From: Jean Fraser
To: Stephen Bushey
CC: Jim Biskup; John.Kraft@safelite.com
Date: 2/24/2016 4:00 PM
Subject: Staff comments Re: Safelight

I am responding to your letter dated 2.23.2016. These are my formal comments:

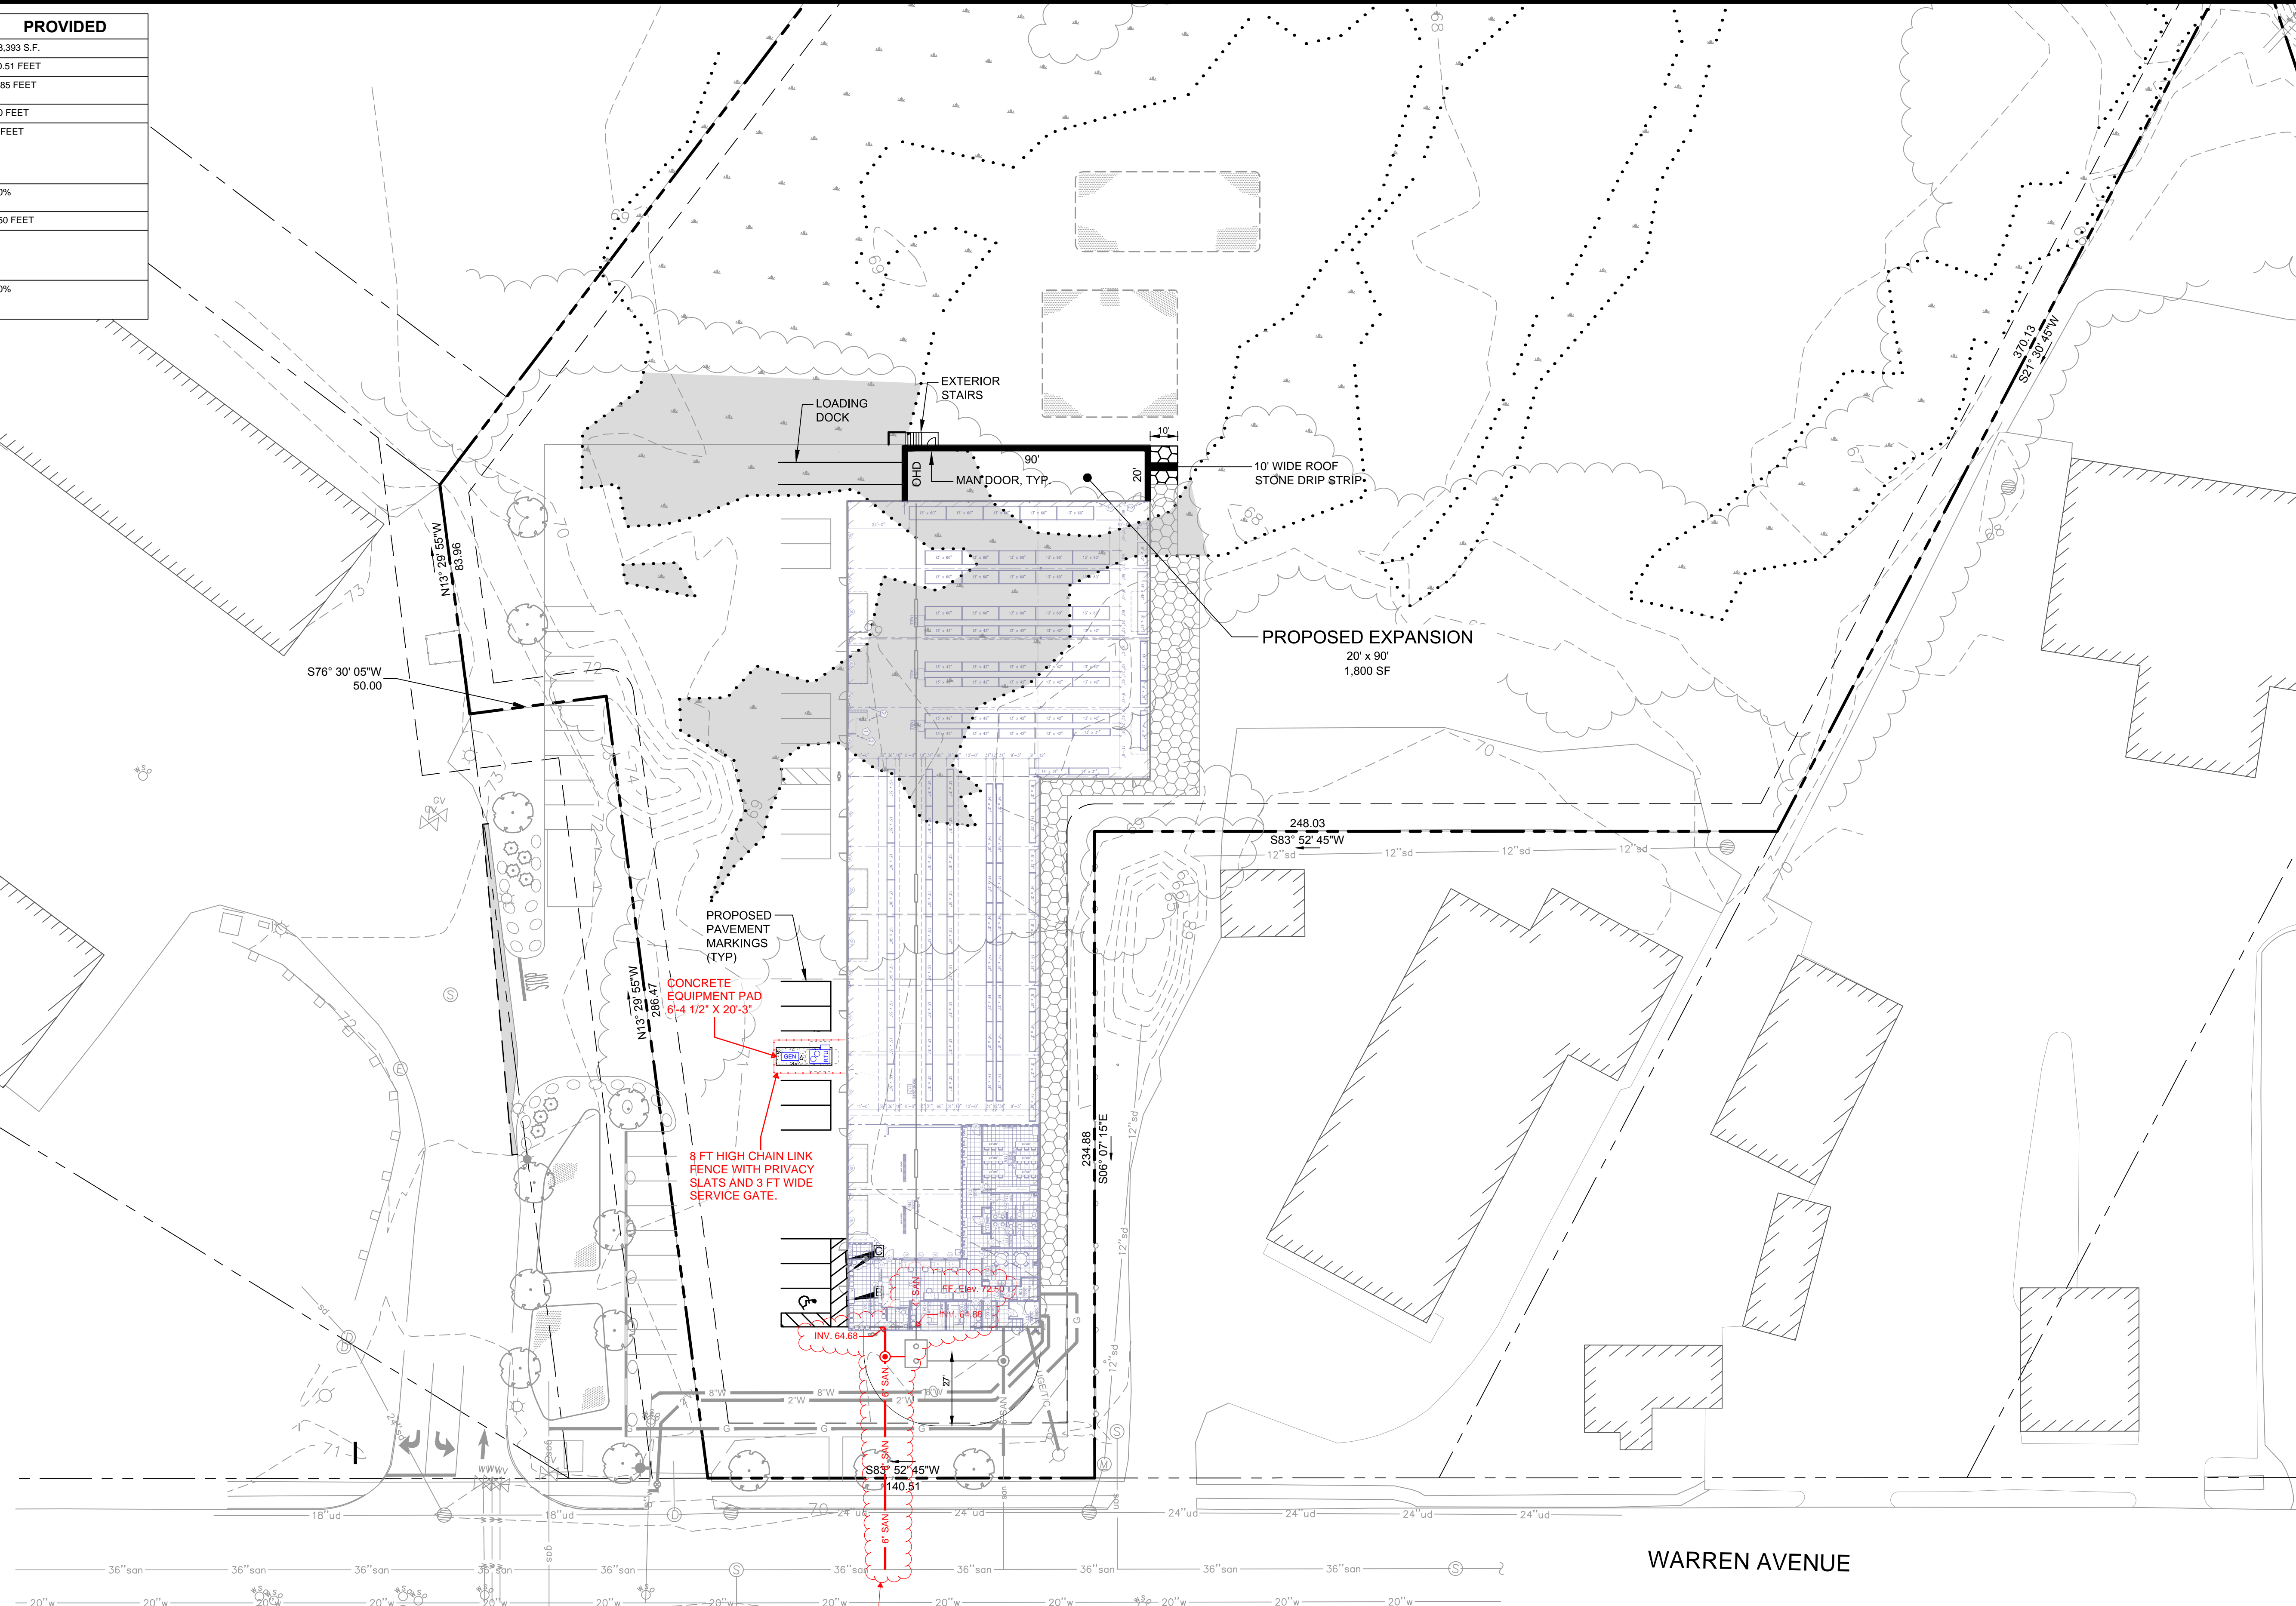
1. **Generator:** I have spoken with Ann Machado, the Zoning Administrator, as meeting the sound requirements is a zoning requirement. She confirms that we need documentation of the maximum sound levels at the property line when the generator is operating normally. If a wall is needed around the generator to bring the sound levels into compliance, we would request that you send similar documentation that (with the wall) the sound levels will be at or below the zoning requirements at the property boundary. We would like to see the calculations that include the distance between the property line and the generator and the attenuation over that distance along with the baseline sound levels of the unit. This information is routinely requested for generators, condensers and other potentially noisy HVAC and mechanicals.

A wall with landscaping would seem a good solution subject to evidence that this would achieve the necessary attenuation of the sound.

Please note that the ownership and proximity of adjacent buildings is not relevant as the abutting lot could be sold and redeveloped.

2. **Parking:** I have not had a chance to discuss the revised parking layout and access details with Tom Errico, the Traffic Engineering Reviewer as he is away this week. I would like him to review this in terms of safety in the vicinity of the entrances for the public as there is no physical separation- he may suggest structural bollards so that people in the walkway aren't at risk of being hit by a parking car.
